Your ref:
Our ref: 22/01762/F
Please ask for: Miss Joanne Wren
Direct dial: 01553 616233
E-mail: borough.planning@west-norfolk.gov.uk

4 October 2022

Details: **Extension to the existing agricultural building, rainwater harvesting tank and an extended concrete apron around the tank and extension, including vehicle access tracks into the building. The proposals also include landscaping features such as grassed areas and trees planting in order to improve the appearance of the site and provide screening at Hill Farm Boughton Long Road Barton Bendish King's Lynn Norfolk**

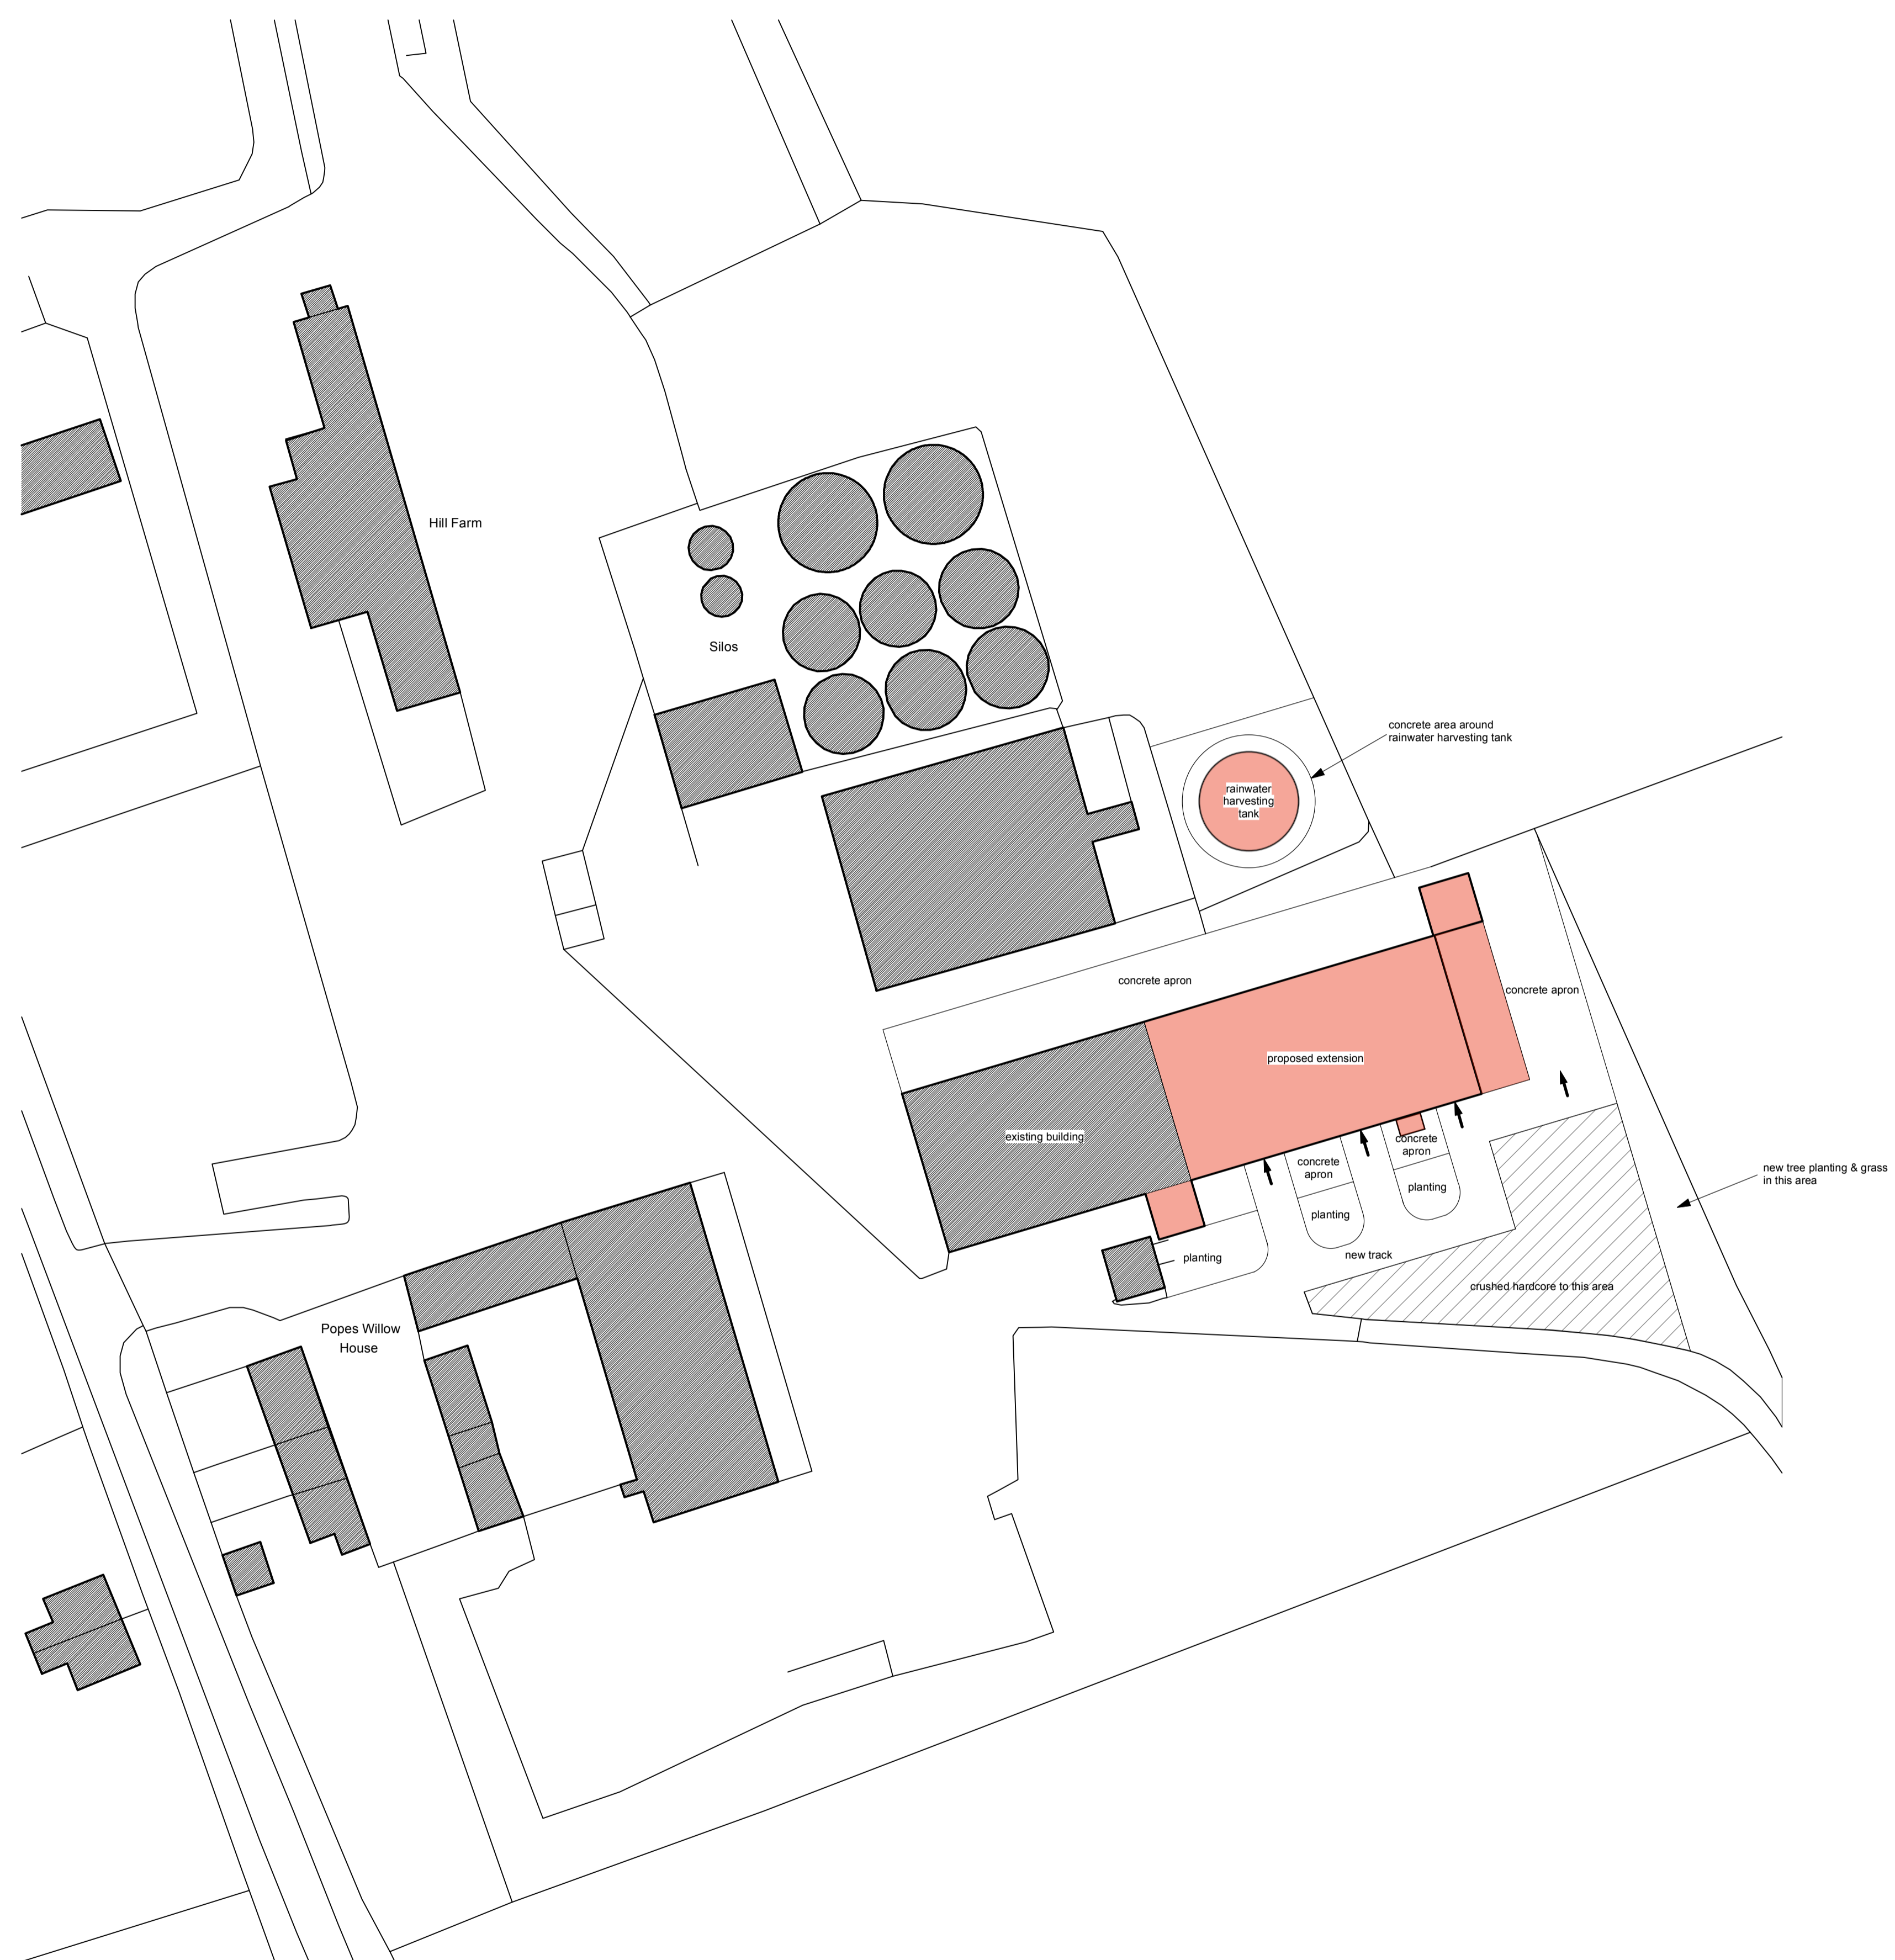
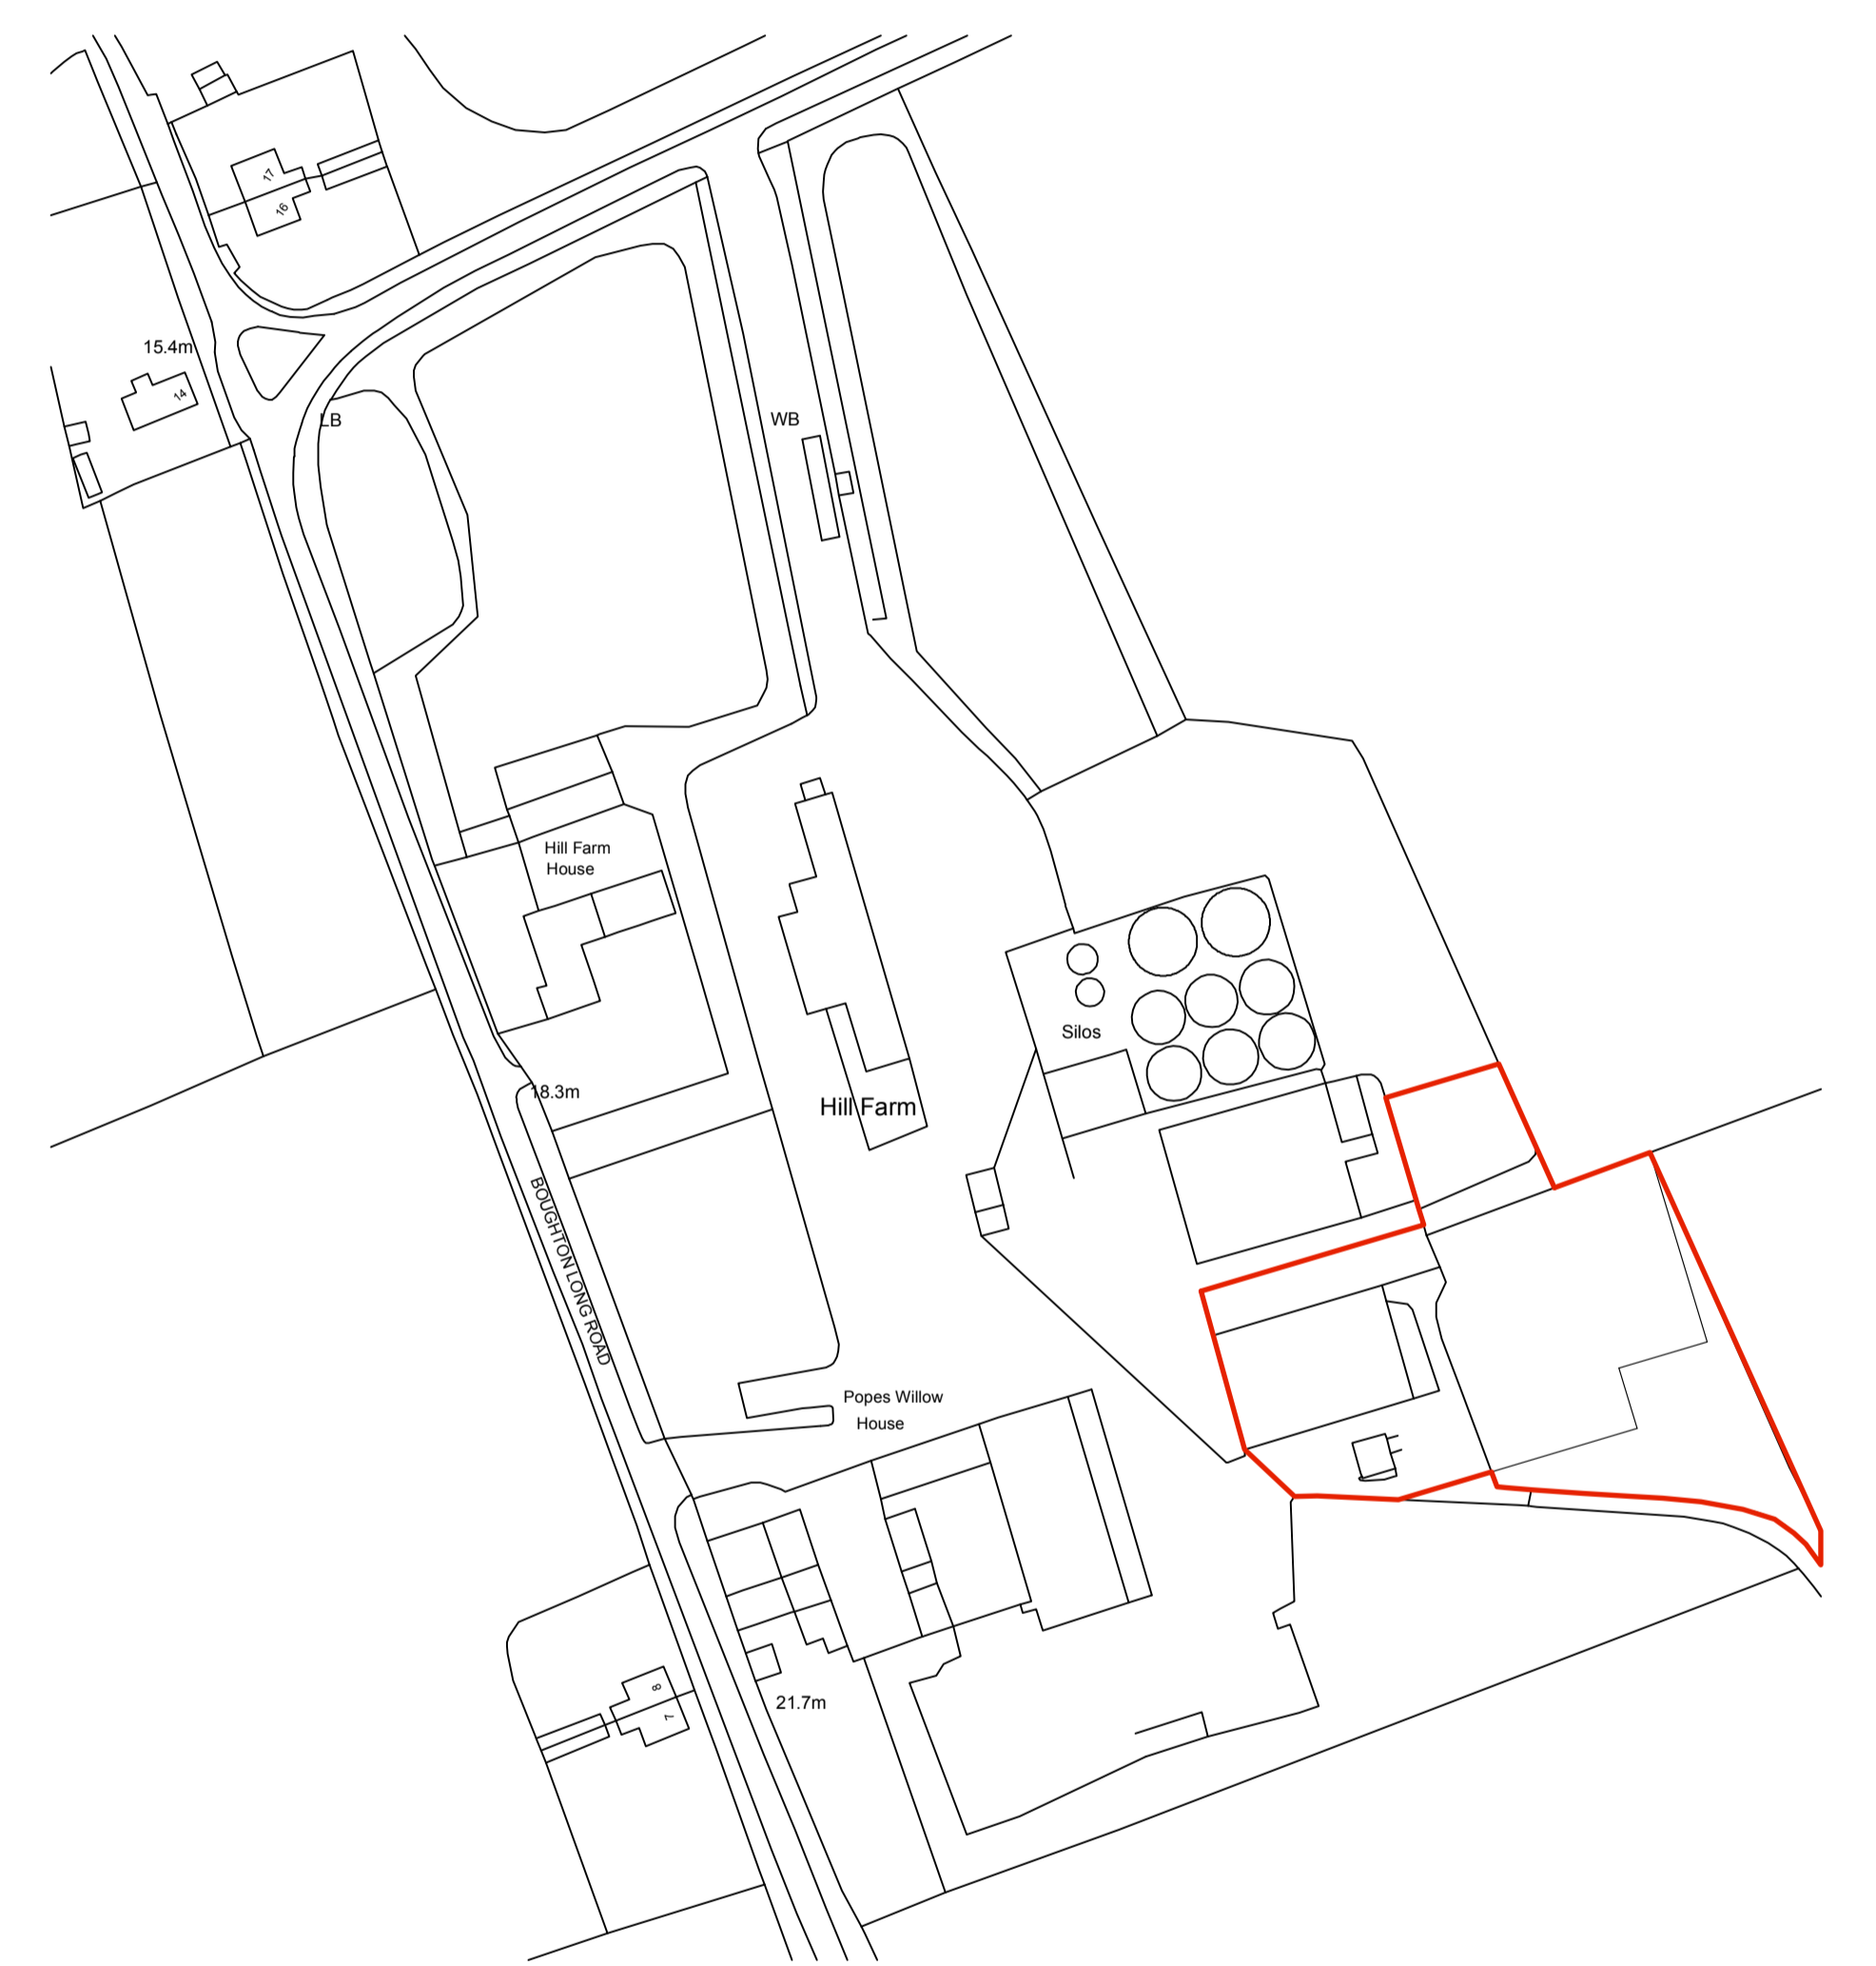
The fee for this application is based on created floor space and is £462 for the first 540 square metres + £462 for each 75 square metres (or part thereof) in excess of 540 square metres. Although you have not submitted existing and proposed floor plans I have measured the created floor space shown in a peach colour on the site plans and this is 908 square metres. Therefore the fee for this application is £2772.

3. Please provide drawings to a recognisable scale, showing existing and proposed site levels. If the site levels are to remain unchanged, please provide the drawings annotated as existing and proposed.
4. Please submit a section through of the proposed extension, this should be done to a scale of 1:50 or 1:100.
5. Please submit an elevation of the proposed concrete surround of the tank, this should be done to a scale of 1:50 or 1:100.
